Subject: Re: LU/340/21/PL - The Old Printworks - EXTENSION OF TIME/AMENDS TO DRAWINGS.

that I agree to an extension of time EOT for the planning application at The Old Printworks , 7 Arundel Road, Littlehampton

TA 1374 / 12 rev. **B**

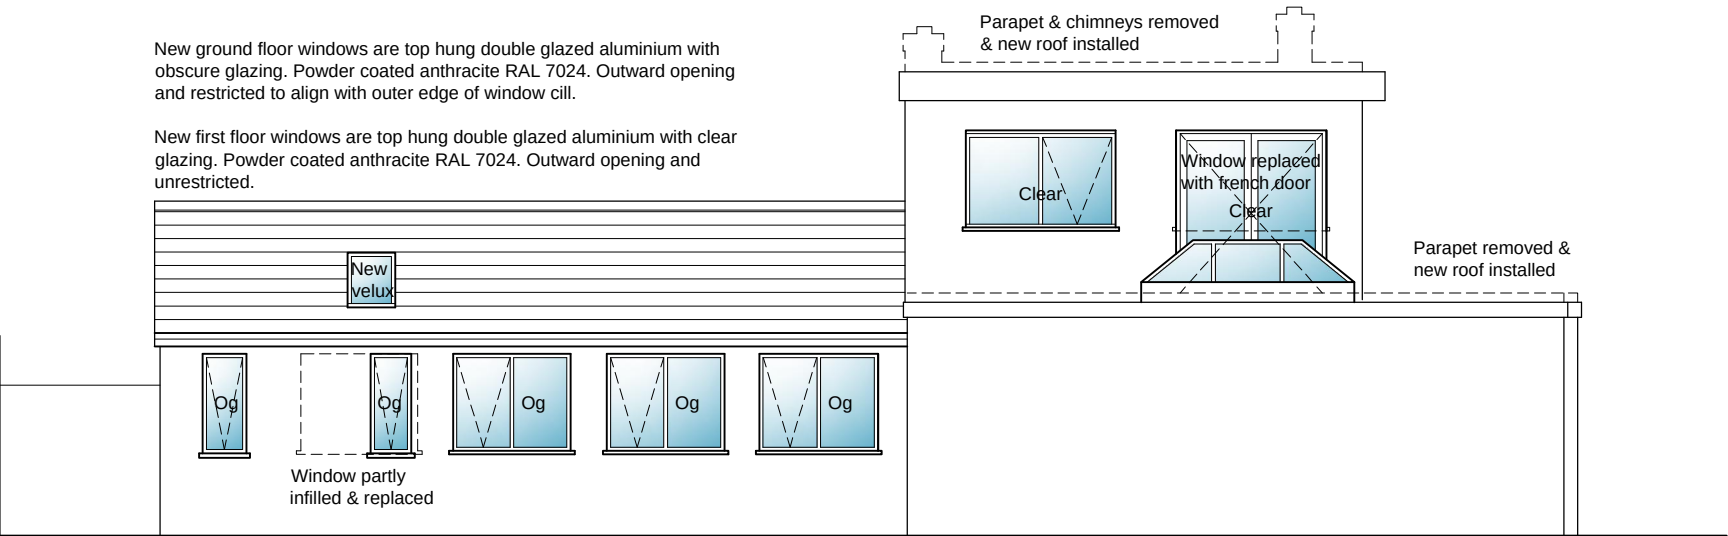
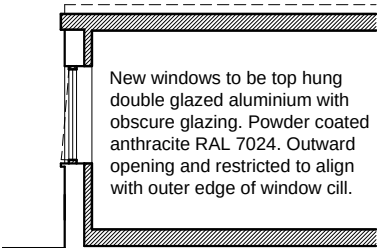
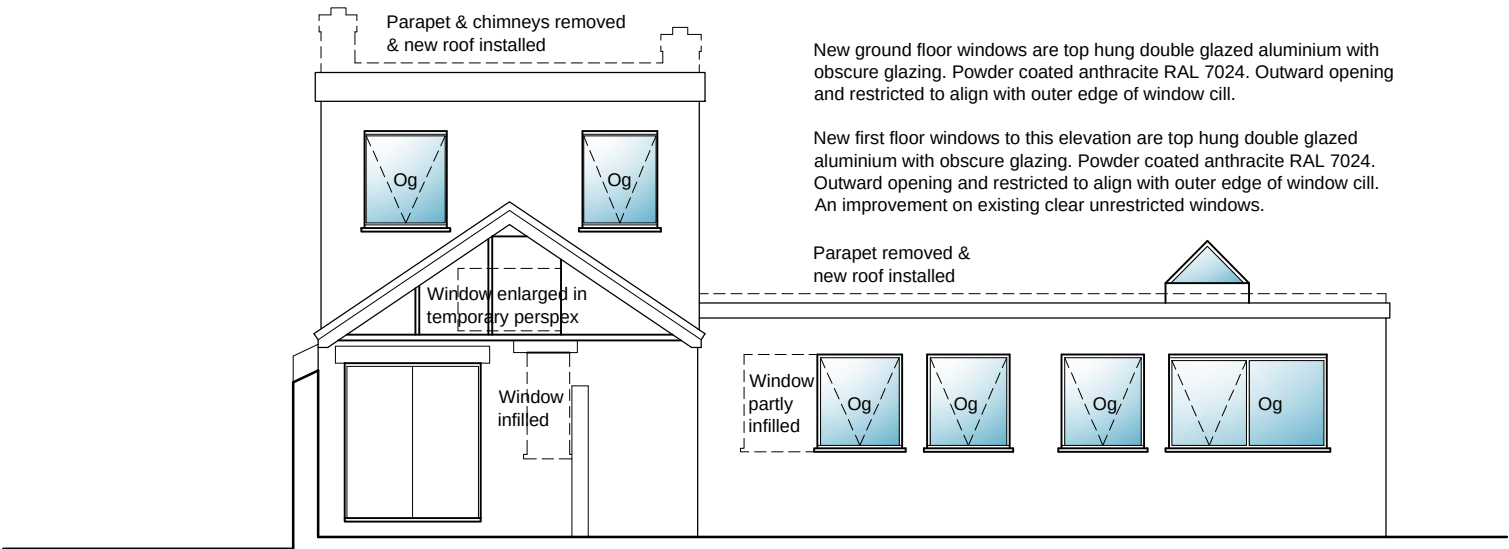
Window Sill dimension
Amount the windows opens

Also I need amended drawings this week as below, photos are not sufficient – planning decisions are legal decisions and need to be tied in with proper drawings, not just photos.
